INTERESTED PARTY REFERENCE NUMBER: [REDACTED] (VILLAGES AGAINST PYLONS)

Norwich to Tilbury Development Consent Order

Issue Specific Hearing 4 (ISH4) Action Point 5

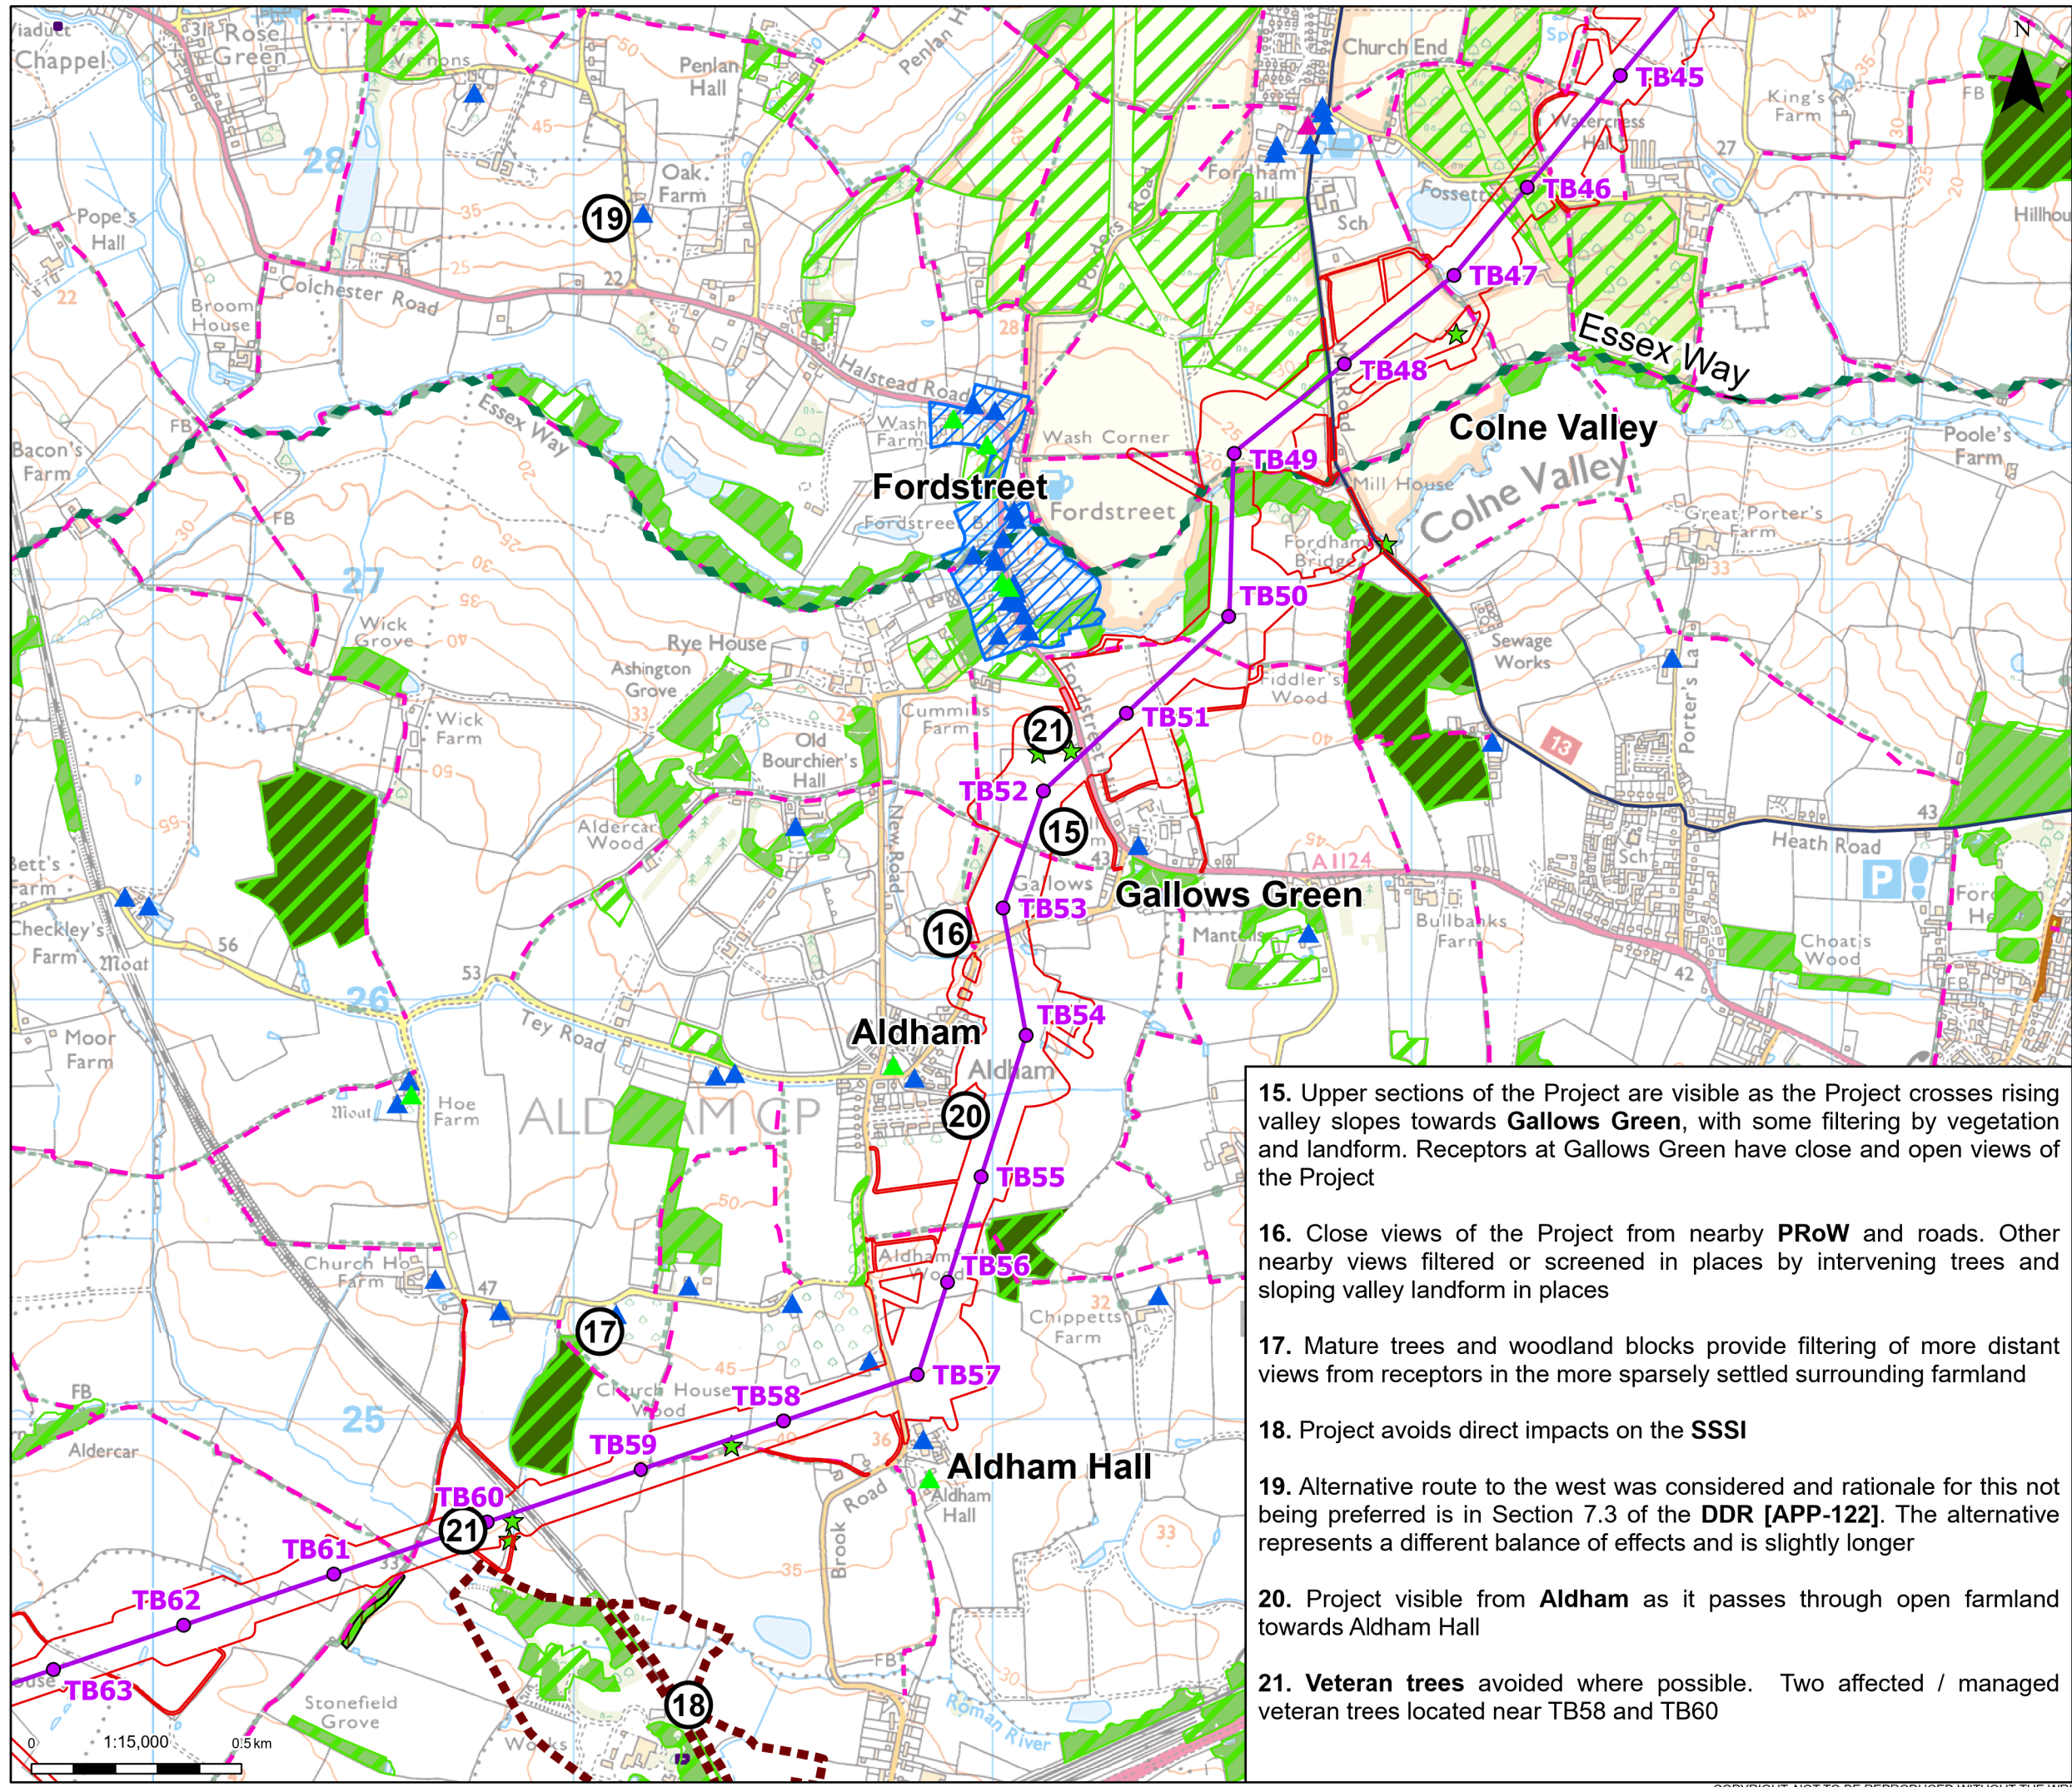
In respect of the Colne Valley, they proposed three elements: (i) planting a hedgerow along the road that crosses the valley to the north-east of Fordham, presumably to screen pylons TB36-TB50 from view within the Colne Valley; (ii) small plantations of woodland near TB50, close to the valley floor; and (iii) the introduction of "connective corridors", without specifying what these would be.

First, screening the Valley from view would not reduce harm to, nor mitigate the impact of, pylons within it. Rather, it would curtail views across what is an open landscape and prevent people from experiencing its natural beauty – a harm, not a benefit. It may also endanger road users: the road in question is a narrow single-track road with few passing places, several sharp bends and deep ditches, and a hedgerow as proposed would render oncoming traffic invisible to drivers. At the same time, the hedgerows would do nothing to mitigate views of the Valley from the Essex Way or from Hill House Woods.

Second, the Valley is already highly connected in ecological terms. Introducing new "corridors" risks disrupting the existing ones and damaging long-established habitat connectivity. The Woodland Trust's Fordham Hall Estate – at over 500 acres, the largest woodland creation site in eastern England – already encompasses a carefully planned mix of grassland, broadleaved woodland and wetland habitats; 120 hectares (300 acres) of new native woodland and 60 hectares (150 acres) of grassland have already been planted, with 19km (12 miles) of unsurfaced paths providing public access. The site is deliberately managed to support diverse wildlife, including otters and water voles, and contains two groups of ancient cricket bat willows thought to be around 200 years old (see:

In addition, some of the proposed opportunities appear to prioritise screening of the development rather than conservation of the existing landscape character. For example, the Draft Opportunities Plan for the northern part of the Colne Valley identifies opportunities to close views of the Project from receptors on the elevated plateau around Fordham through additional hedgerow planting.

Whilst reducing localised views of the proposed infrastructure may have visual benefits, this approach does not reflect the characteristics of the landscape. One of the principal qualities of the elevated land around Fordham is the opportunity to experience expansive panoramic views across the Colne Valley towards its wooded valley sides and rolling landform. These open views are a fundamental component of the area's scenic quality, perceptual experience and appreciation of the wider valley landscape. They contribute directly to the landscape's value and to the way in which the Colne Valley is experienced.
